Your Ref: OWPC13811
Our Ref: R/64/17/PL 17-03-2017
Please ask for:
Mr D Easton

Demolition of 1 No. dwelling & erection of 4 No. dwellings. This application affects the character & appearance of the Station Road, East Preston Conservation Area.

St. Marys Close Hurst Road Rustington

Thank you for your internet representation made on 2nd May 2017 which has been recorded as '**an objection**' with the comments as follows:

Drg No: 151117_SS-01 Rev: D

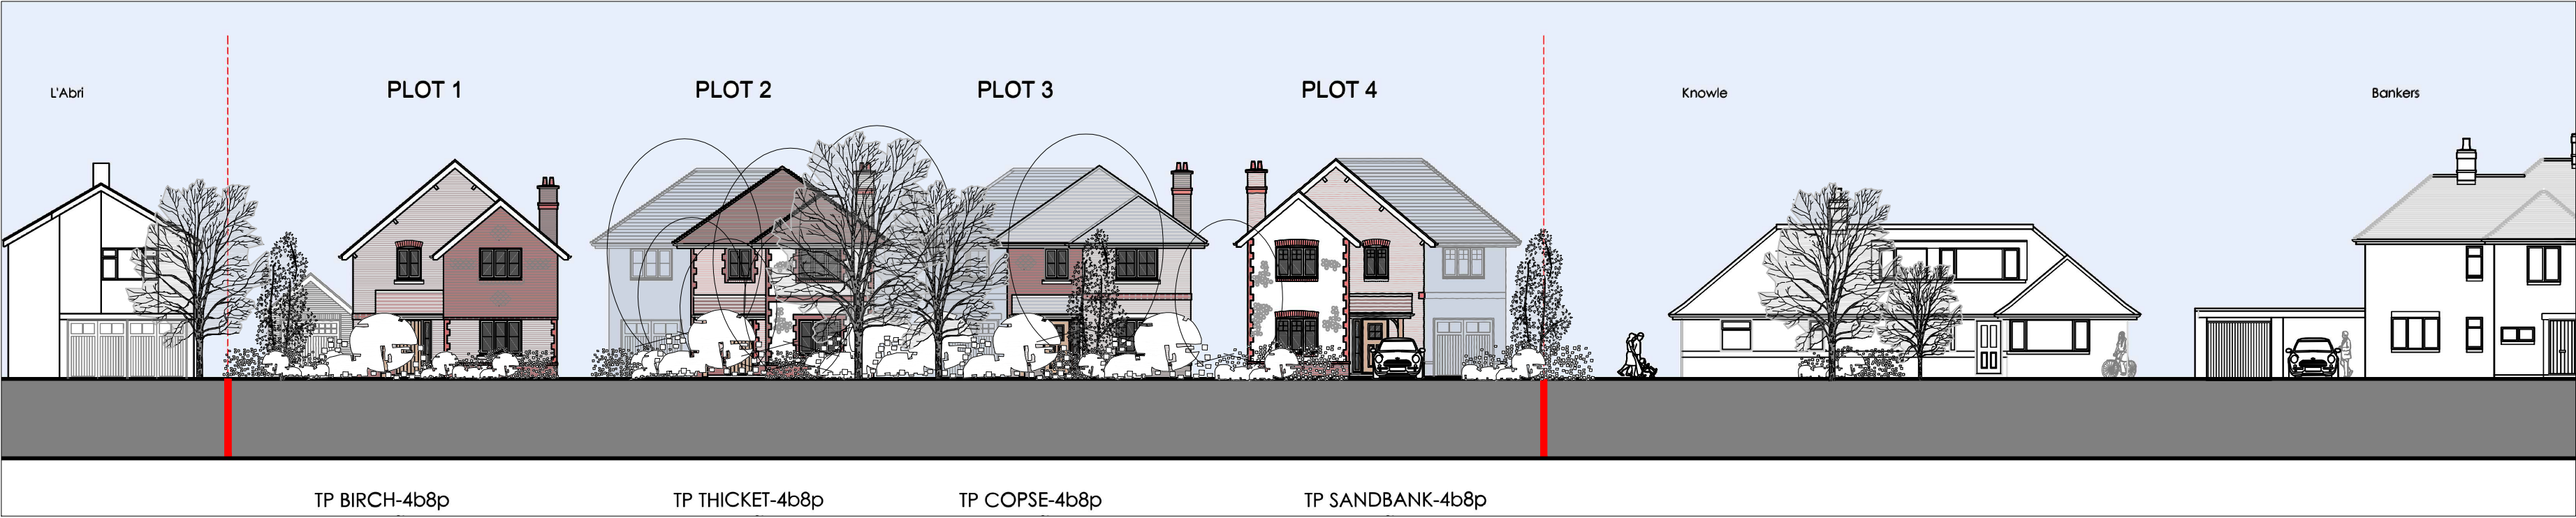
2 Street scene - Hurst Road properties are all unique in their design and construction so we would also object to this application on the grounds that the proposed houses are not designed to be in keeping with the individual aspects of all of the existing properties. From a planning perspective this proposed development will contravene the local plan D DM1 Aspects of design and will not meet the aims of the National Planning Policy Framework by reflecting the identity of local surroundings.
